**DRAINAGE REPORT**  
**for**  
**Desert Ridge Trails North**

March 10, 2003

**Re: Desert Ridge Trails North Subdivision ZAP C-19 (COA Rpt B19-D21)**

CITY PROJECT NO. 675483 ZONE MAP NO. B-19-Z SHEET 5 OF 38

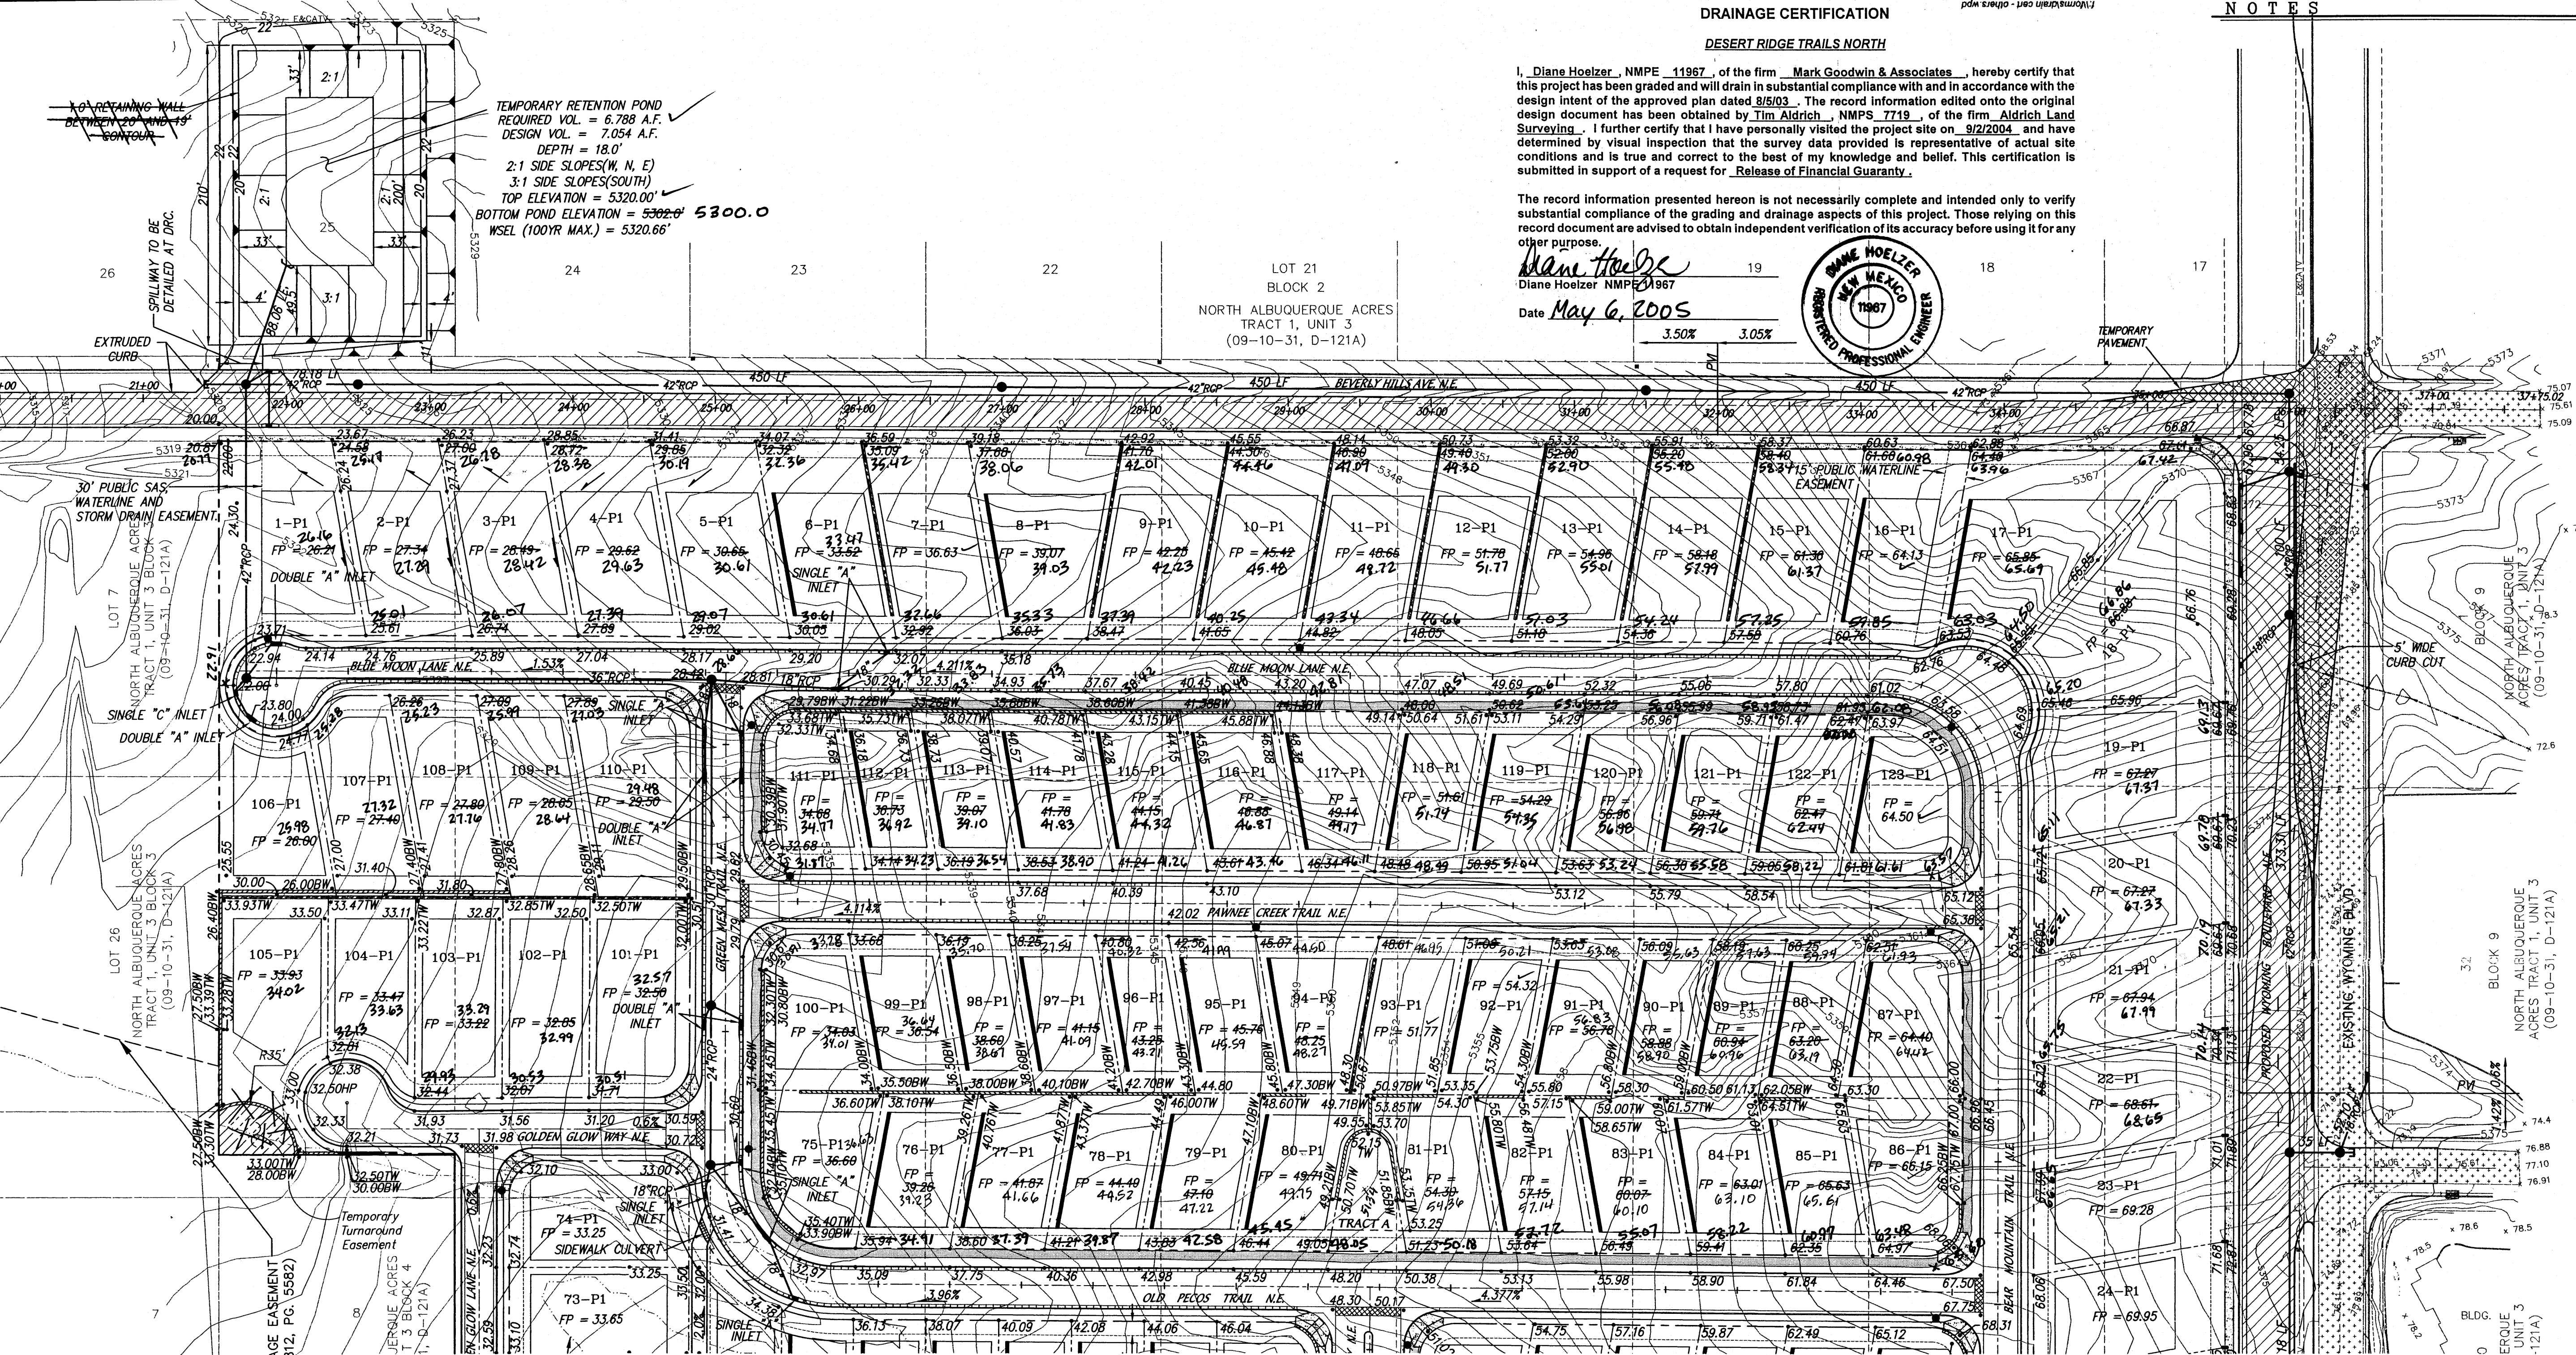
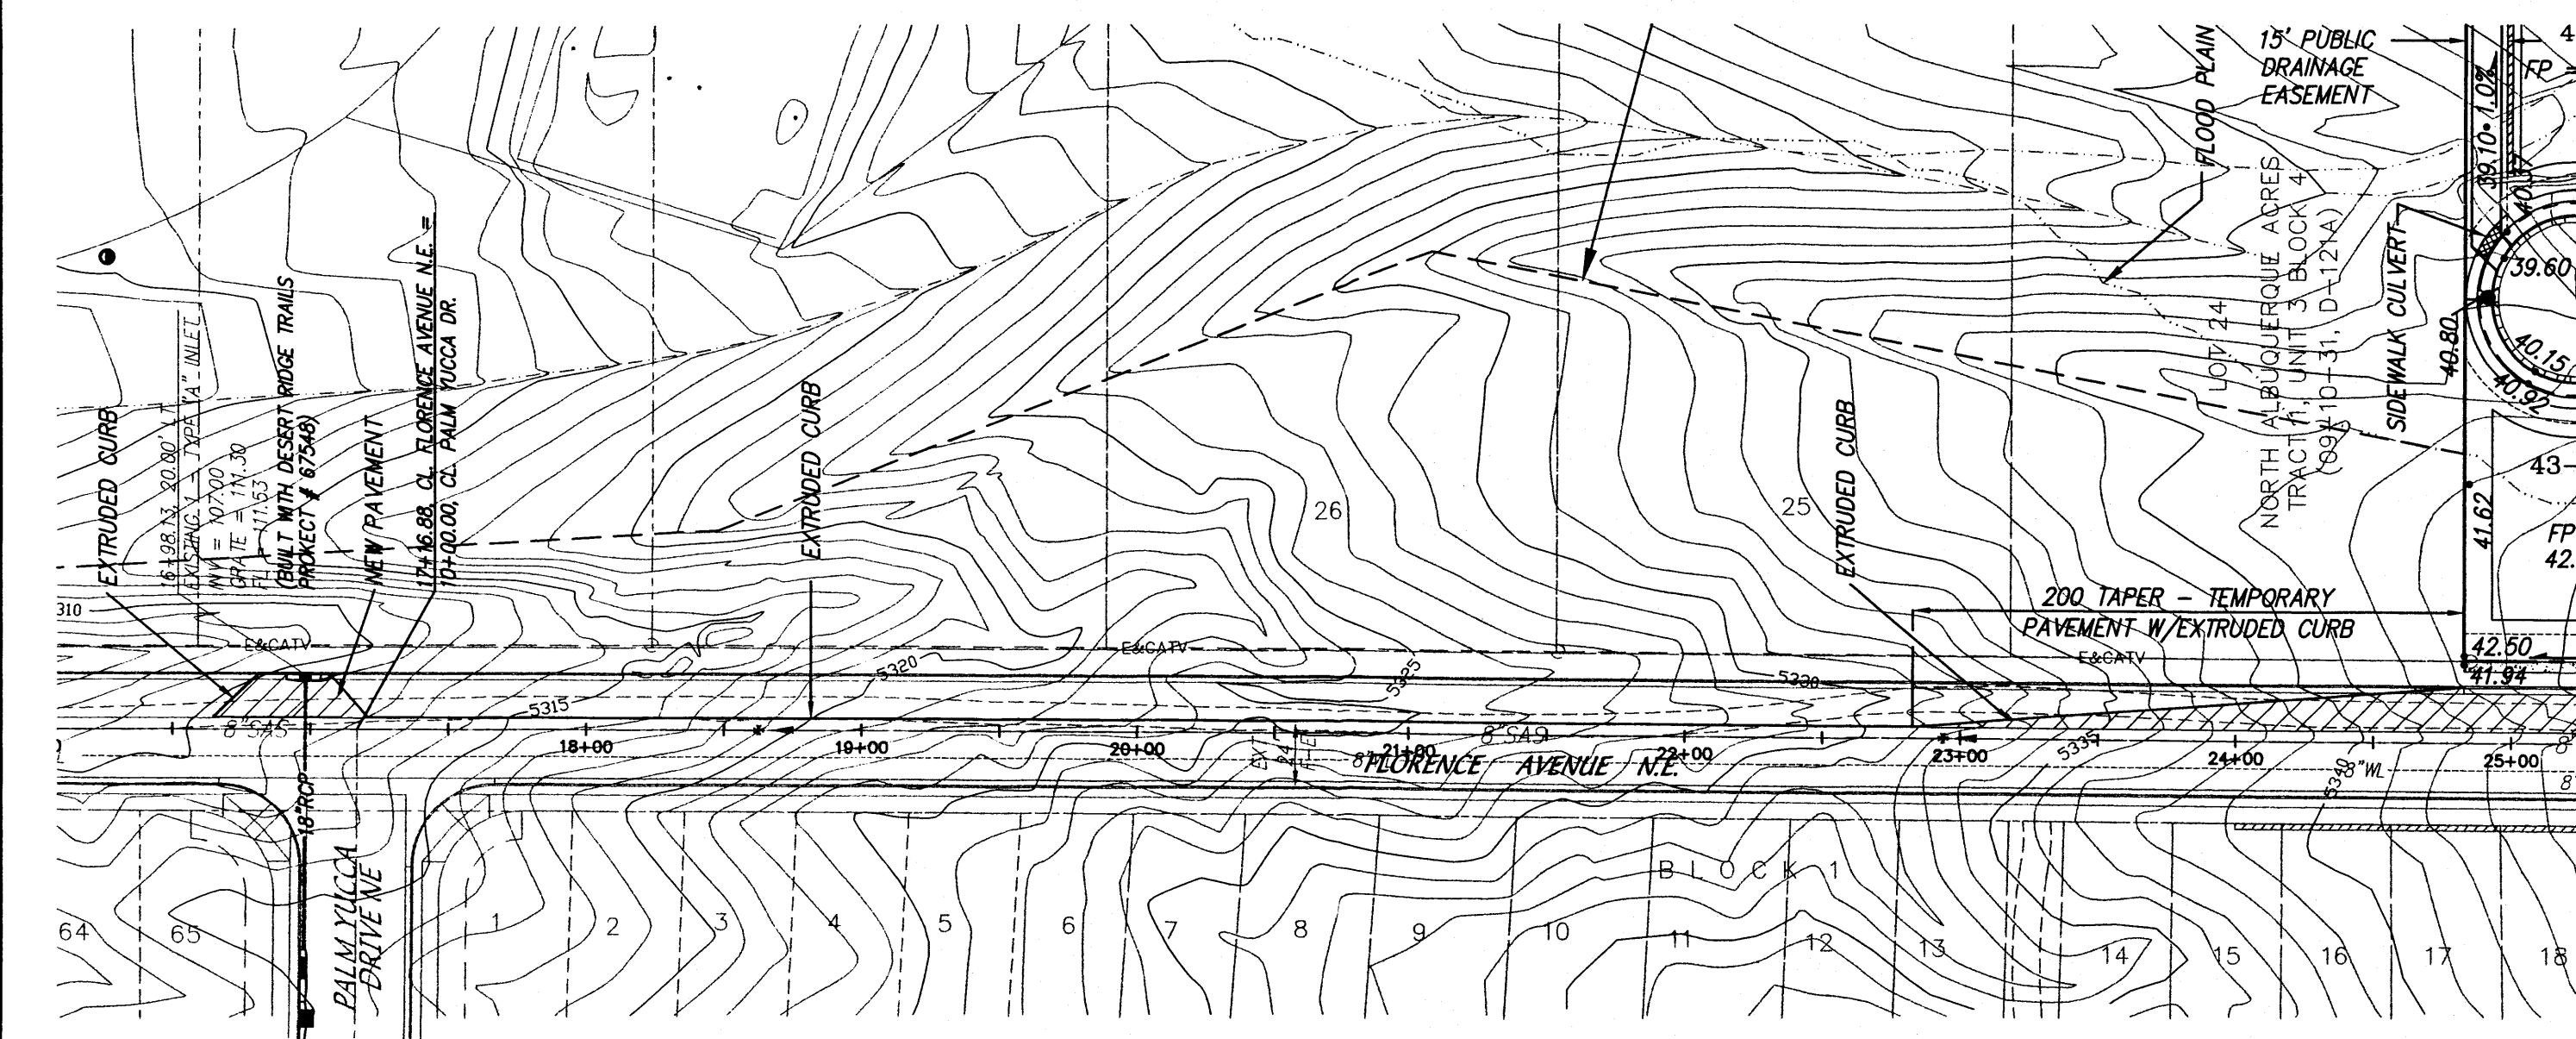
1. Per our March 3 meeting, offsite flows entering Wyoming Blvd. from the east just north of the future Florence Avenue will be intercepted by a temporary detention pond on Lot 32, Block 10 and then conveyed to the proposed storm sewer in Wyoming which will extend to Beverly Hills and then west to the temporary offsite retention pond on Lot 25, Block 2. This offsite ponds will each be granted as a temporary public drainage easement with an accompanying executed Agreement and Covenant with maintenance responsibilities being taken care of by the developer/owner or Home Owners Association.

Offsite flows at the northeast corner of San Diego and Wyoming will be intercepted by a future double 'A' inlet to be constructed at the future curb return of the future Wyoming east lane. For the interim condition the double 'A' inlet box will be constructed with either a temporary Type D grate or beehive grate cover at the existing ground elevation.

Offsite flows originating from Lot 1, Block 9 will be allowed to flow across Wyoming Blvd. and then be intercepted by a series of inlets along the west side of Wyoming Blvd. just south of the Beverly Hills intersection.

3. *The revised grading and drainage plan shows that the additional runoff from the north side of Florence Avenue as a result of construction from this project will be intercepted by an inlet on the north side of Florence at the intersection of Palm Yucca Drive. This inlet is already constructed and connected to the existing storm sewer system in Desert Ridge Trails. The Storm sewer analysis for this system was included in Appendix C as 'Stormplus Florence Avenue Diversion'.*

4. *The revised G&D plan gives all the required dimensions necessary to construct the pond for the required runoff capacity. Historically, as shown on the 'Existing Offsite Drainage Conditions Exhibit', runoff from our project site and offsite subasins 204.1AE, 204.1BE and 204.4AE have been diverted along the south side of and in Beverly Hills Avenue and then across Louisiana and back into the natural arroyo channel. Per our meeting on March 3, the proposal is to construct the south half of Beverly Hills from the west end of our project site to Louisiana Blvd. and divert any spillway flows from the pond in Beverly Hills westward across Louisiana and back into the arroyo. This will be accomplished in a 24' wide pavement section with curb and gutter along the south side and extruded curb along the north side.*

*The pond will be dedicated as a 'public drainage easement' and the standard 'Agreement and Covenant' will be executed with either the developer or the Home Owners Association being responsible for maintenance of the pond.*
5. *Under existing drainage conditions, Lot 7, 8 and 9 drain in a west to northwest direction. This historical flow pattern will not change with this development. At this time our client has control over Lot 9. The access issue has been resolved through the creation of a temporary turnaround easement as shown on the revised grading and drainage plan and as will be shown on the final plat.*
